From: Melanie Smith [REDACTED]
Sent: 07 July 2021 11:38
To: Kathryn Welch <Kathryn.Welch@arun.gov.uk>
Subject: K/27/21/HH Sandy Lodge Planning Objection

We live at Cloudy Bay, on the east side of Sandy Lodge. We'd like to raise the following objections:

First floor Terrace view over the garden of Cloudy Bay

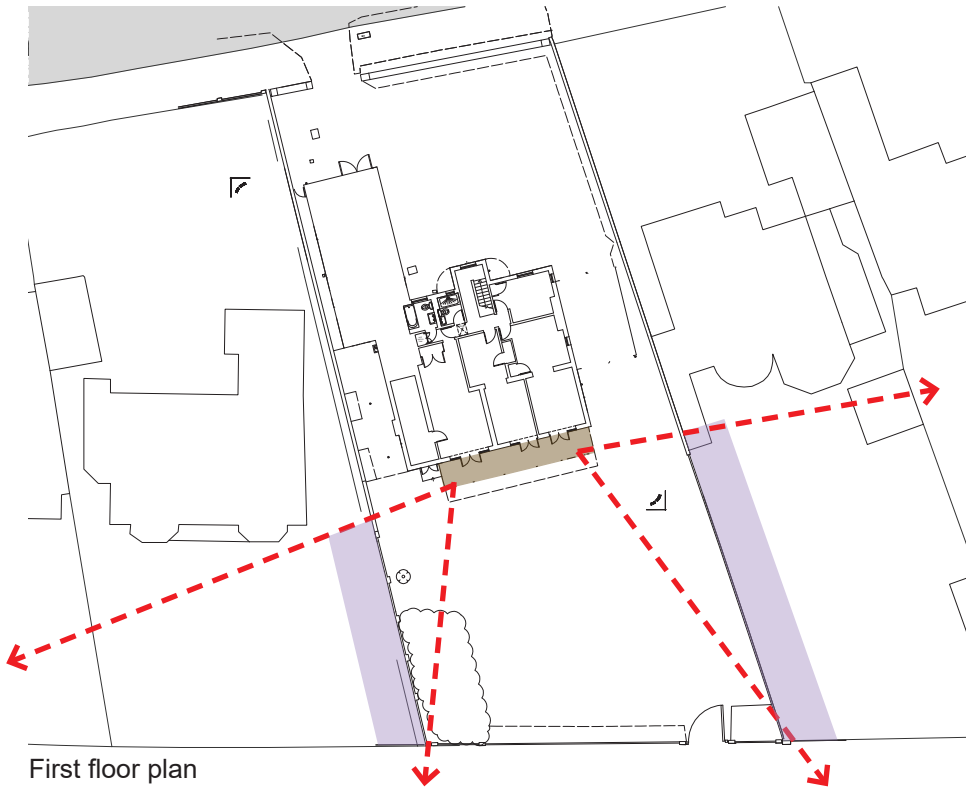
First floor terrace

The first floor terrace provides the only access to the garden from the living accommodation on the first floor. The planning application is for a 7 bedroomed house, 14 people. Whereas terraces in the local area are rectangular and only project say a metre from the house, this terrace extends over the pool building to reach the steps down to the garden. We consider this to be unneighbourly and will have an overbearing impact on the enjoyment of the private amenity space of Cloudy Bay.

South elevation/ section through swimming pool

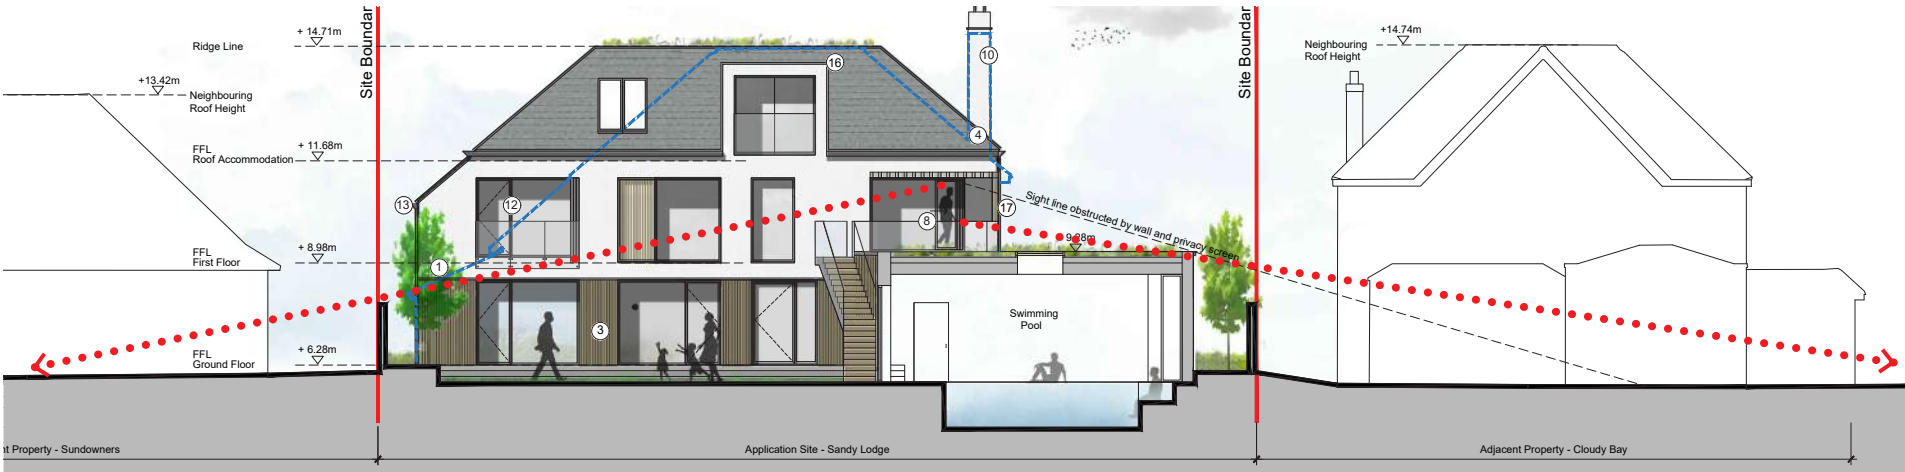
Swimming pool building

The swimming pool building is high in itself, and even higher to the top of the screening. It is long, longer than the main body of the house, built forward of the building line and very close to the boundary. It takes up most of the garden space. We feel this will be overbearing on our property and garden, and overshadow the whole length of our garden. Planning permission granted for Little Deerswood kept the extension into the garden to a minimum with the rear extension sitting some 26 metres from the Greensward boundary.
